12 June 2012

**RE: Section 75W Modification (MOD 1) to modify MP 10\_0027 (Site 3 – Stages 2 & 3, Sydney Olympic Park)**

I refer to the above Section 75W Application, which was referred to Sydney Olympic Park Authority (the Authority) for comment by letter dated 29 May 2012. The Authority raises no objection to the application provided that the following issues are satisfactorily addressed:

Site 3
Sydney Olympic Park
Plan
Level 22

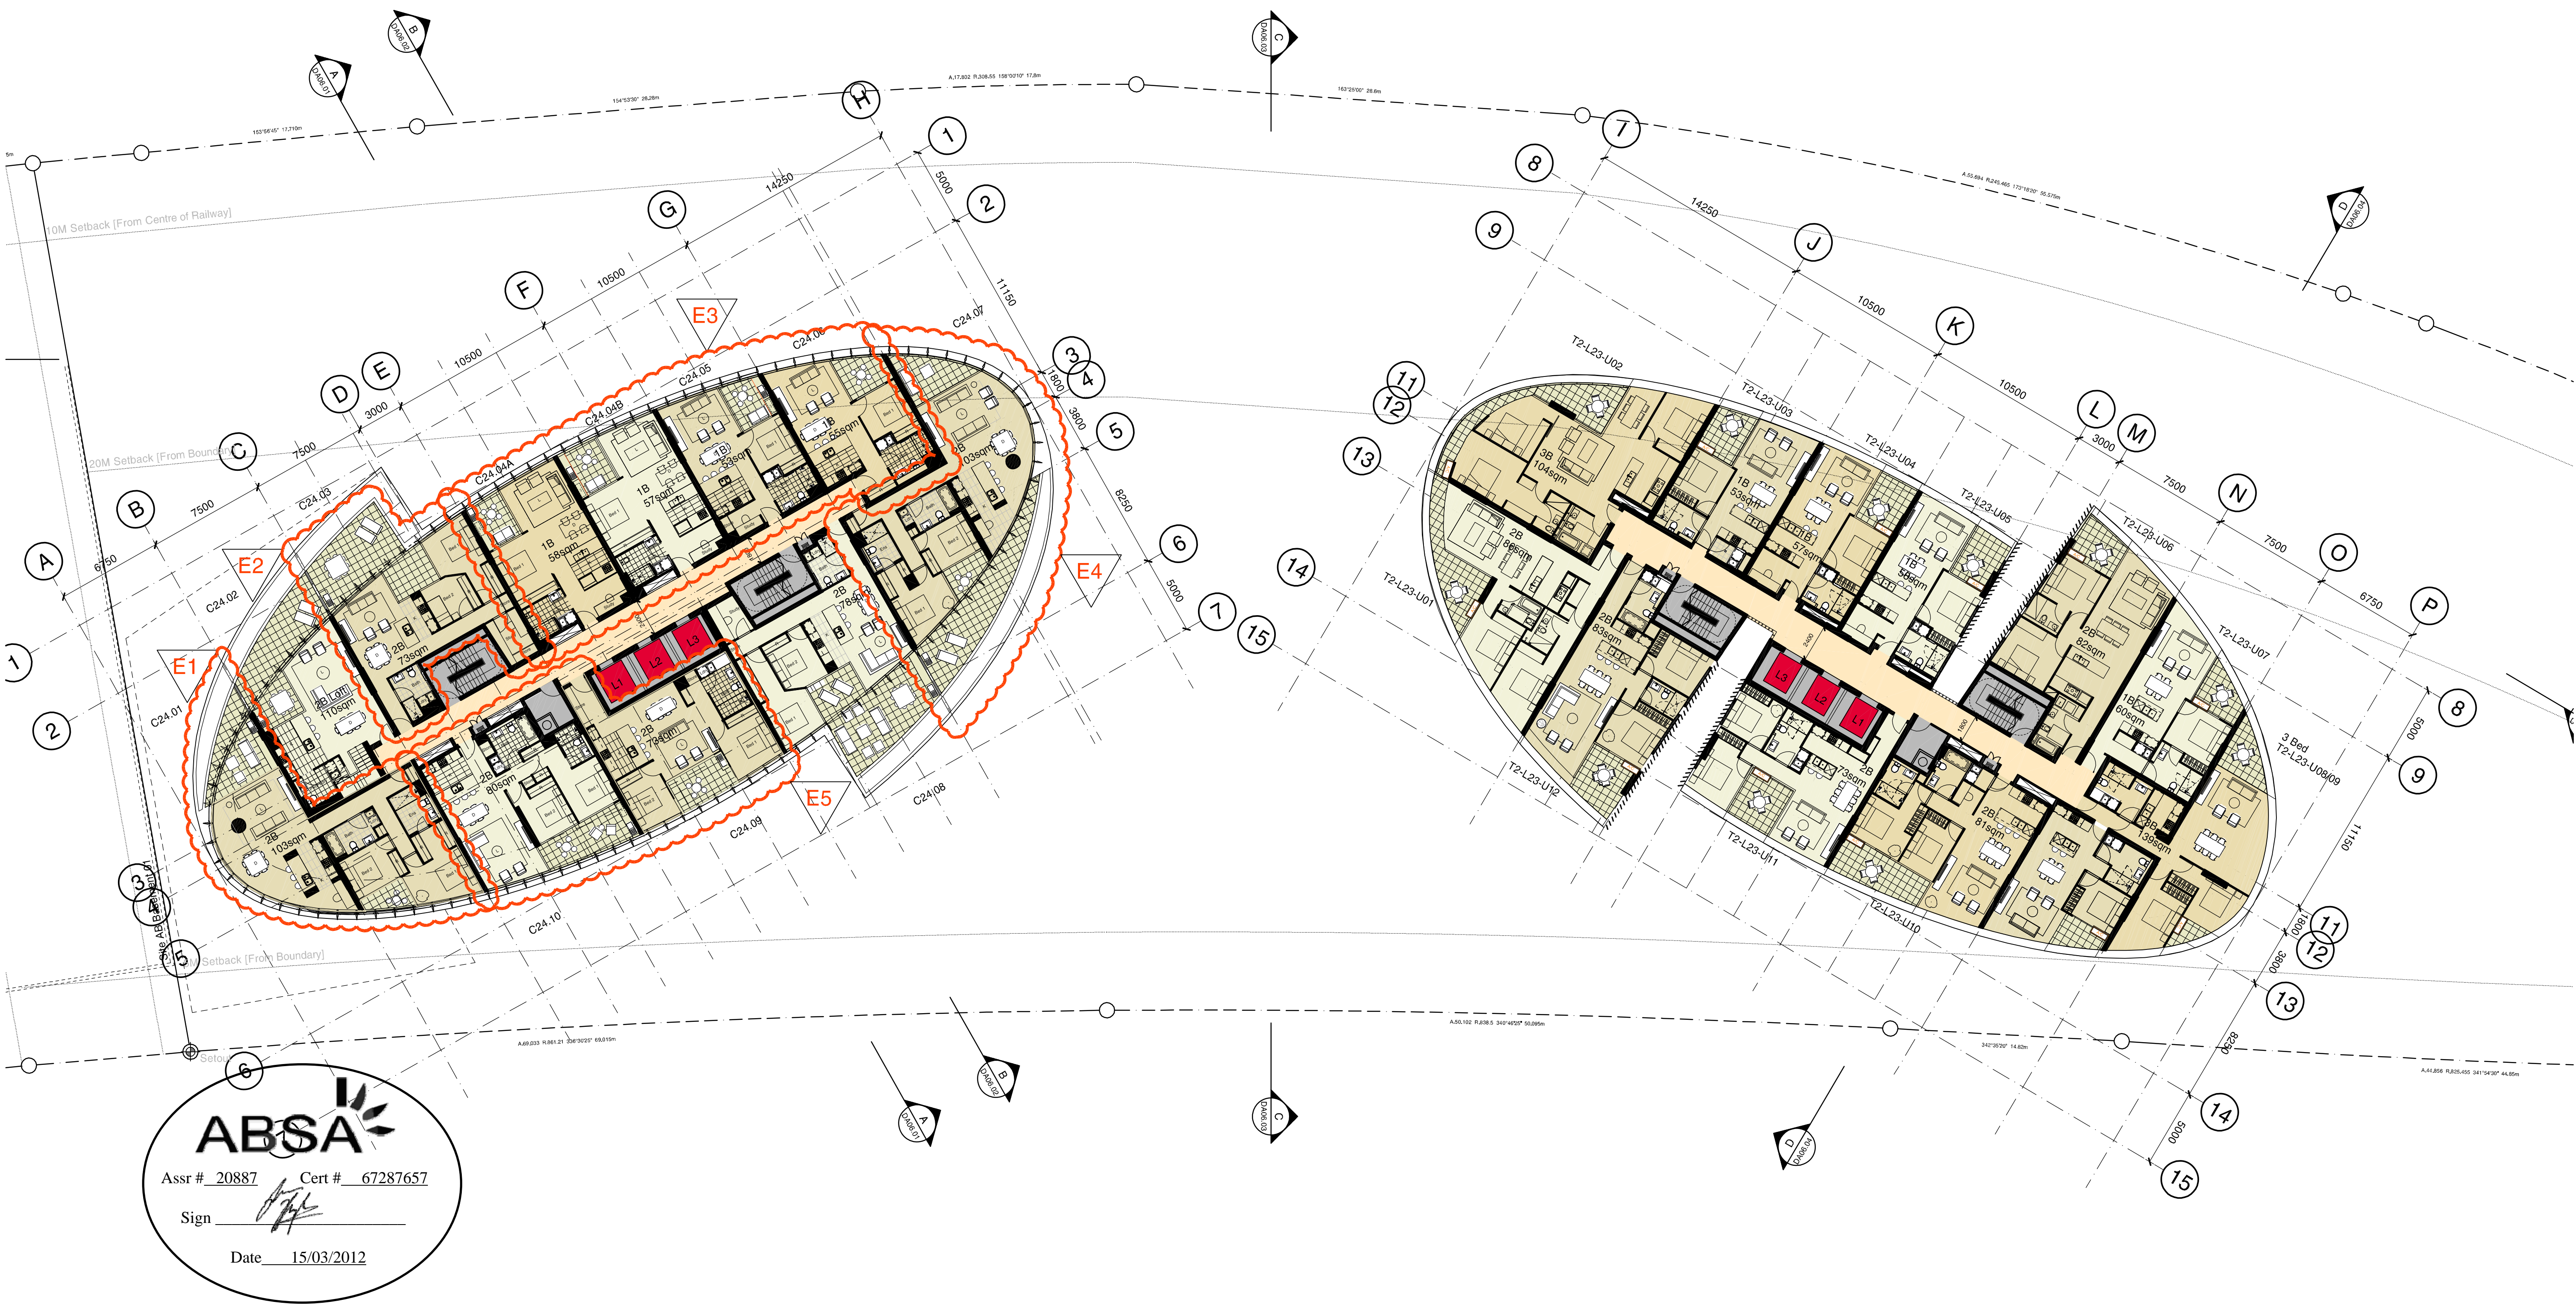
- There is a reduction in variety of unit options with the removal of all but 1 loft unit. The proponents have indicated that they wish include more 1B unit due to market demands, which in real terms is reasonable. However, due to the size and strategic location of the development, it is important the Department consider the overall cumulative impacts of non-compliance with the Master Plan. This may in the future preclude families or any other similar groups from residing at Sydney Olympic Park.

The change in unit mix has resulted in new triangular balconies that are less than 2 m<sup>2</sup> in area and almost unusable. It is recommended that the additional FSR achieved through internal efficiencies (52m<sup>2</sup> in total according to the proponent) be invested back into providing balconies of greater than 2m<sup>2</sup>.

Site 3
Sydney Olympic Park
Plan
Level 23

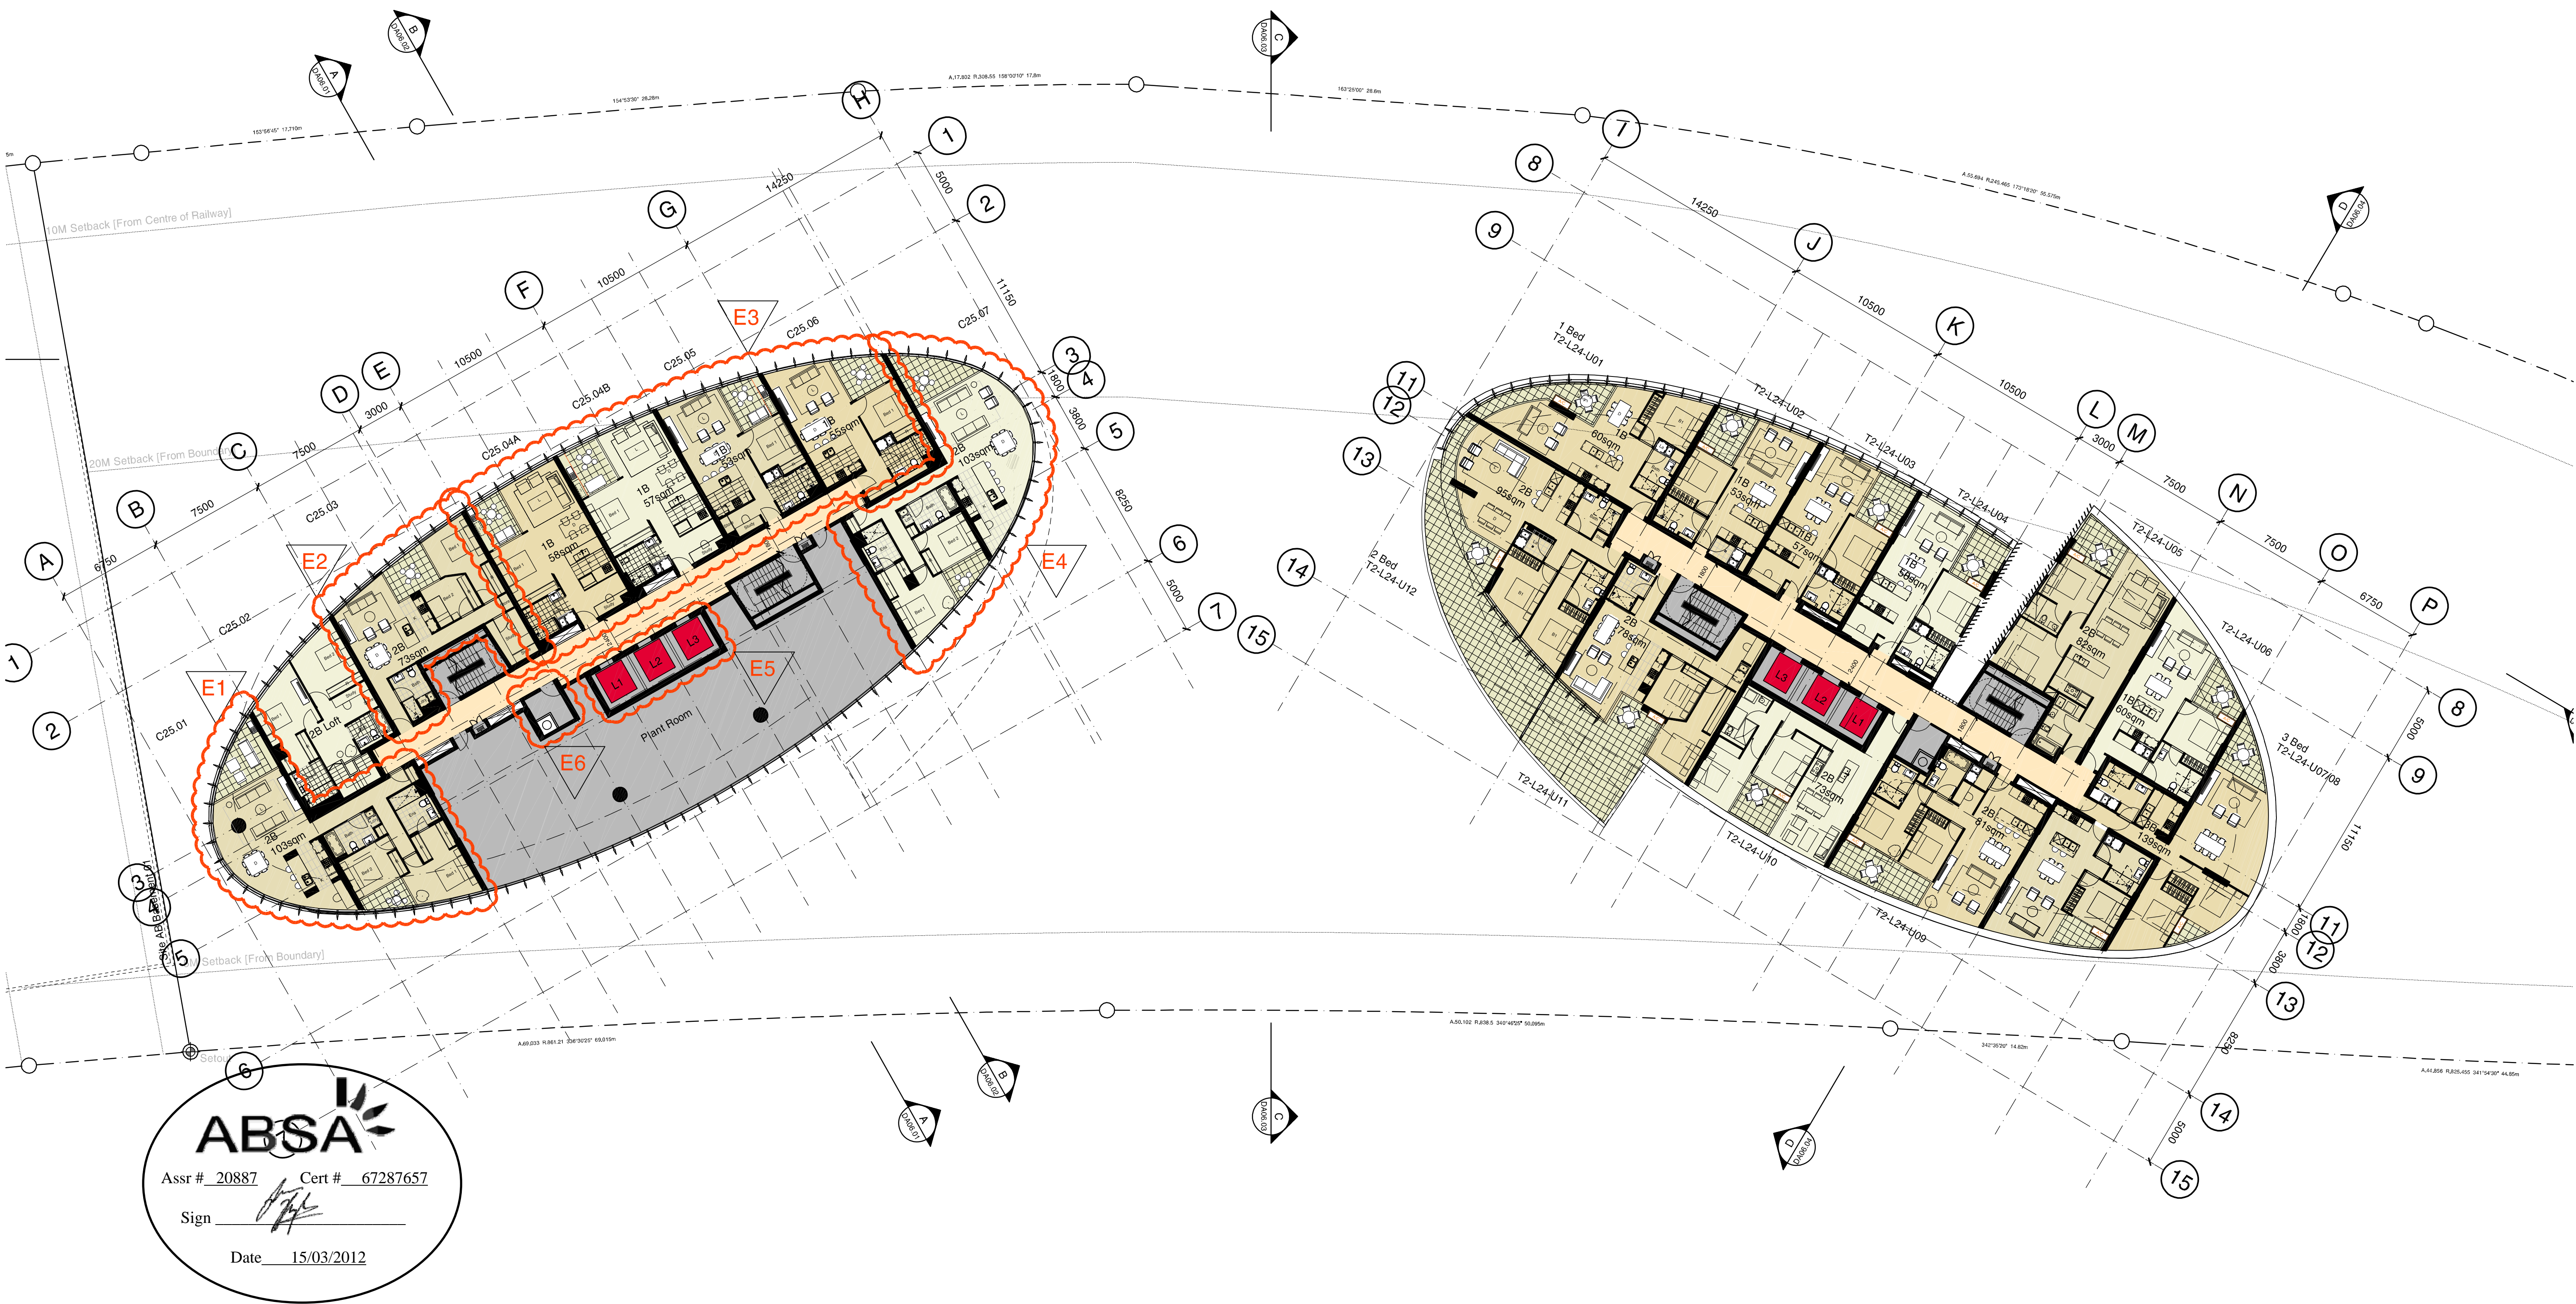
- Smaller, shallower balconies and fewer external wall surfaces set back from the building edge are less effective in counteracting the mass of these large elevations.
- Removal of 2-storey loft units reduces the variety and changes the proportion of the upper levels. The removal of the loft units also means that there is less light penetrating through the 2-storey voids into the Level 23 living area
- Infilling the void areas at each end of Level 24 reduces the variety, transparency, and solar access of the upper levels.
